# M5 Junction 10 Improvements Scheme

**Statement of Common Ground  
Environment Agency  
TR010063 – APP 8.4**

**STATEMENT OF COMMON GROUND**

This Statement of Common Ground has been prepared and agreed by (1) Gloucestershire County Council and (2) the Environment Agency.

Figure 2-2 River Chelt bridge cross-section

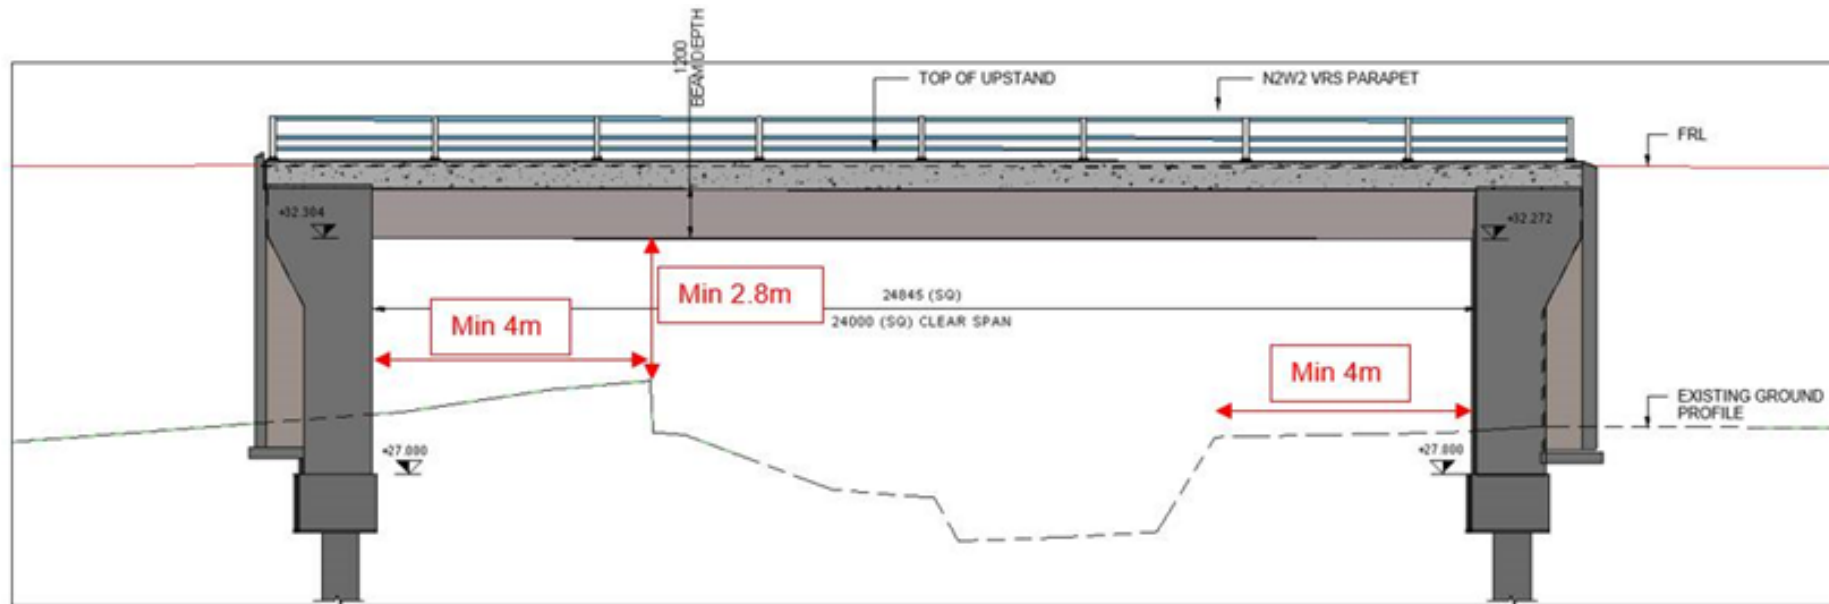
7.2.	<p>West Cheltenham Link Road River Chelt Bridge</p> <p>A single span structure is the preferred type of crossing to minimise impact on the water environment if designed appropriately. The EA welcome the clear span structure with no mid channel features with reduced interactions during the operational phase with the river bed and banks. However within the PEIR, there were conflicting descriptions of the geometry of the bridge in relation to the river. Whilst there will not be the direct permanent habitat loss and significant habitat severance associated with the culverting of the other watercourses there is potential for changes to riparian and associated flood plain quality and as well as water body hydromorphology leading to changes in river processes and habitats upstream and downstream.</p> <p>The Applicant has confirmed the structural dimensions of the proposed bridge (12.05.2022). The Applicant also acknowledged that based on indicative cross sections, the EA have requested greater variety in bank top to bank</p>	Matter agreed via EA review 07.06.2024.

Matter Reference number	Position	Date and method of agreement
	<p>top width to create a more geomorphologically interesting channel. At this time the drawings shared are concept plans and further work will be incorporated at that point to support detailed design (13.01.2023).</p> <p>At a meeting held on 05.06.2024, the Applicant confirmed that ref WE4 in the REAC details the geometry of the River Chelt bridge, therefore the EA are satisfied that there are no conflicting descriptions with regards to the bridge geometry. Refs WE3 to WE9 mentions measures to avoid deterioration to hydromorphology and ref WE15 states that works in the floodplain will be minimised as far as possible. Therefore, the EA are also satisfied that changes to riparian and flood plain quality and hydromorphology have been adequately addressed.</p>
